Date: 26-Feb-2026
Our Ref: 2026/90092

**TOWN AND COUNTRY PLANNING ACT 1990
TOWN AND COUNTRY PLANNING (GENERAL PERMITTED DEVELOPMENT) (ENGLAND)
ORDER 2015 – SCHEDULE 2, PART 1, CLASS A.1 (g)
AT: 8, St Mary's Walk, Mirfield, WF14 0QB
Prior notification for single storey rear extension**

SITE PLAN
SCALE 1:500
DRG NO. 25198

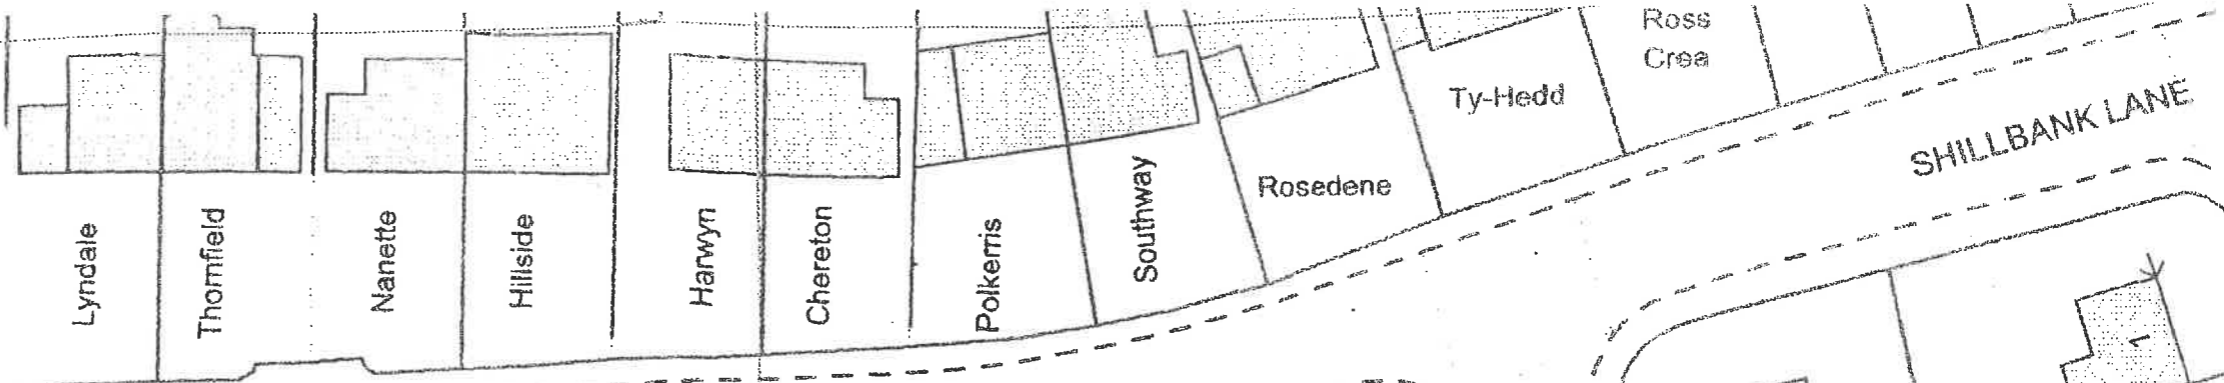
The proposed rear enlargement cannot benefit from a general planning permission under Article 3(1) and Schedule 2, Class A, Part 1 of the Town and Country Planning (General Permitted Development)(England) Order 2015 (as amended) as the proposed enlargement would extend beyond a wall forming a side elevation of the original dwellinghouse and has more than half the width of the original dwellinghouse, and the height of the eaves of the proposed enlargement would exceed the height of the eaves of the existing dwellinghouse, contrary to sub paragraphs (j) and (d).
